**PAVEMENT DESIGN REPORT  
SADDLEHORN RANCH  
FILING 2  
EL PASO COUNTY, COLORADO**

February 15, 2024  
Revised April 5, 2024

**FIG. 1**

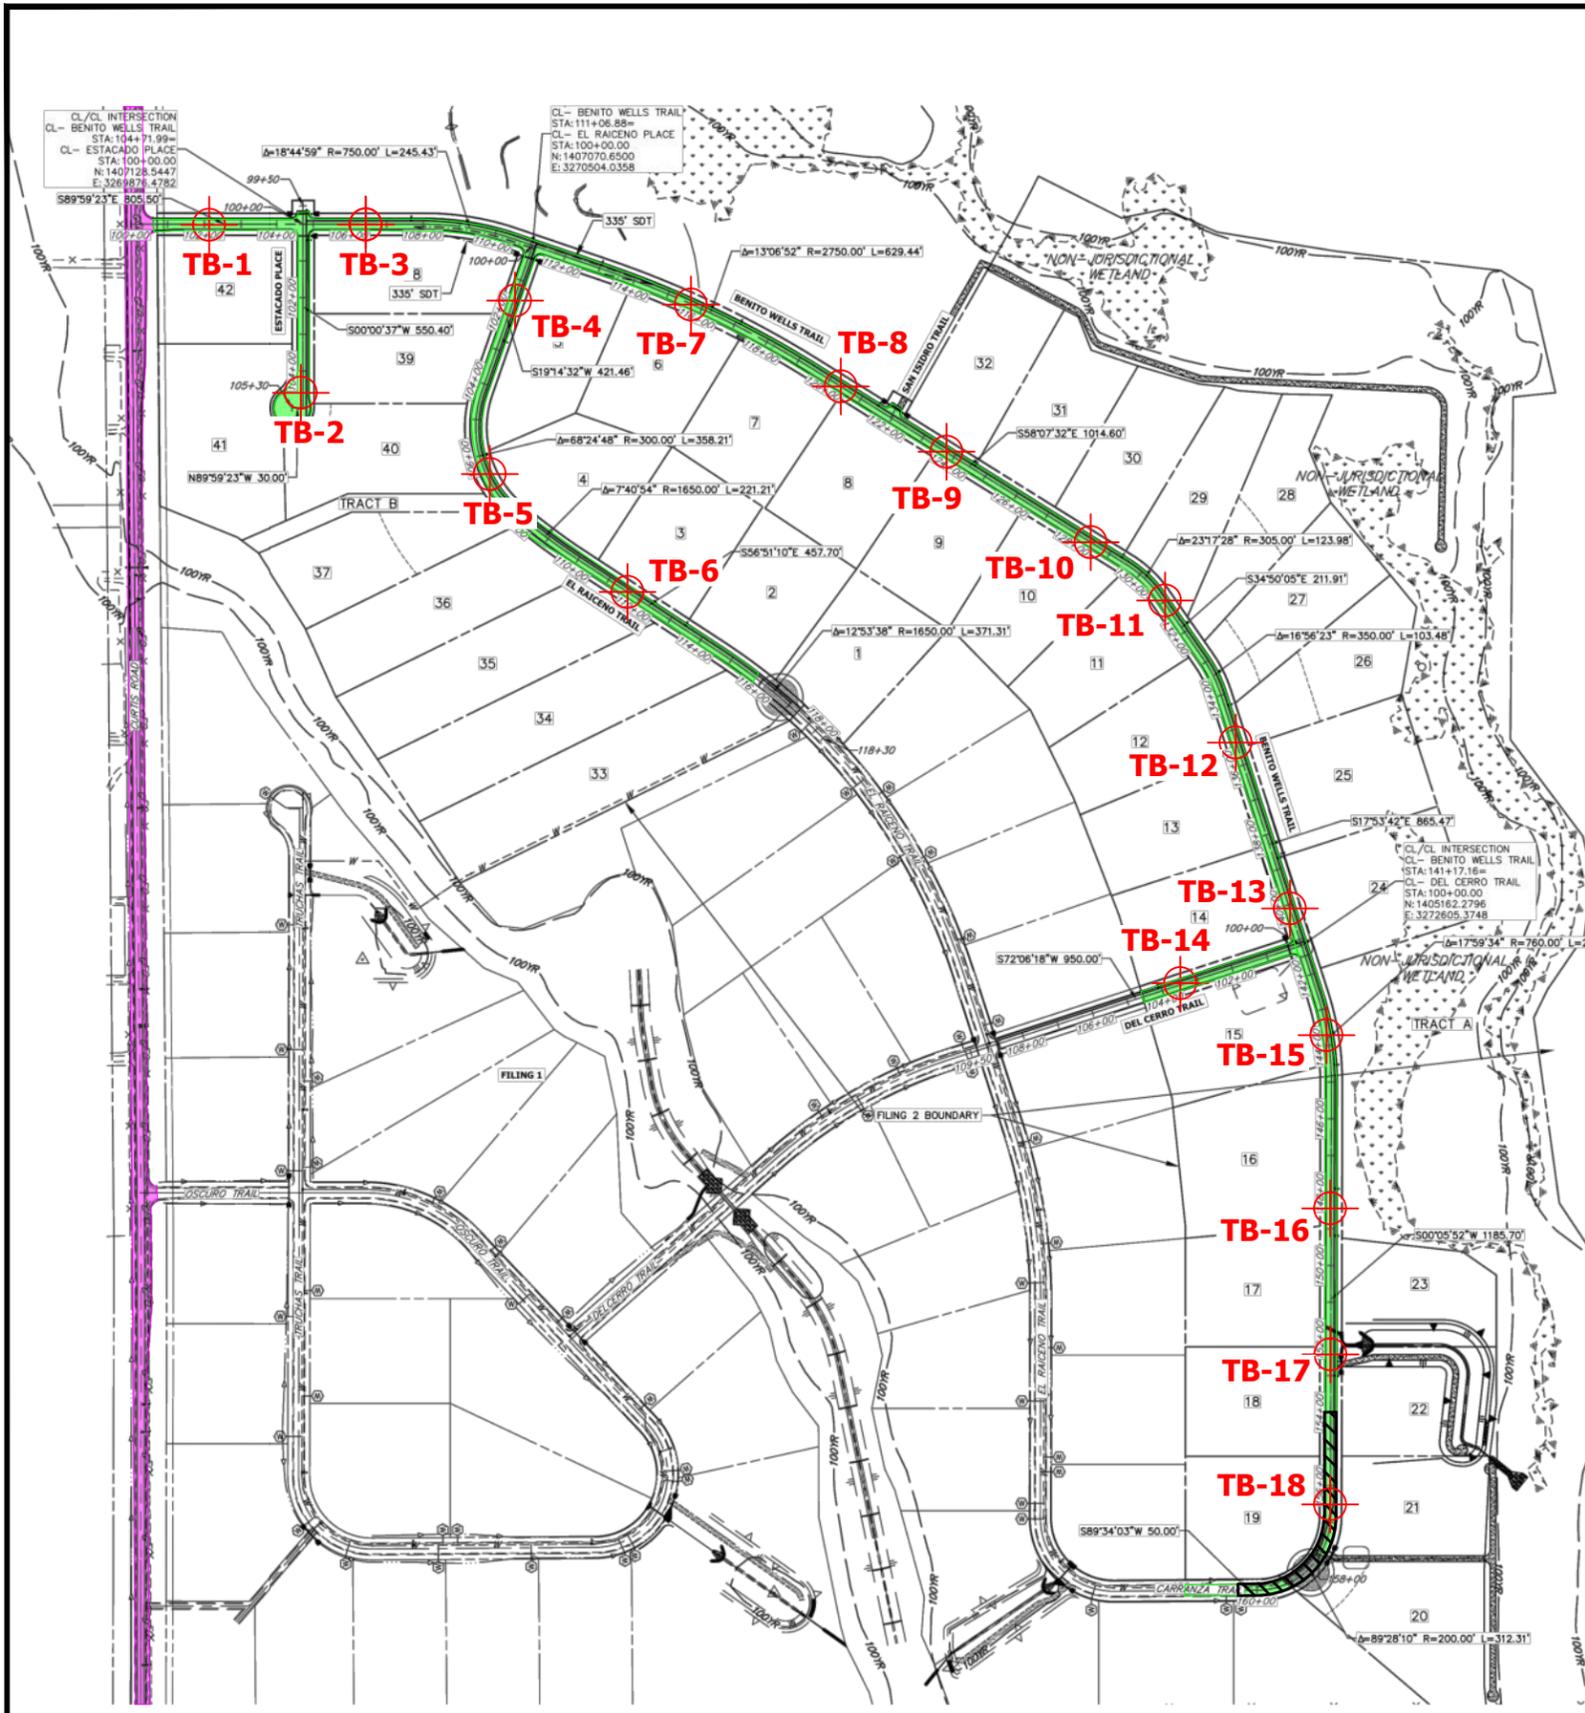
Please include an additional figure or add hatching depicting which roads are included in the pavement report
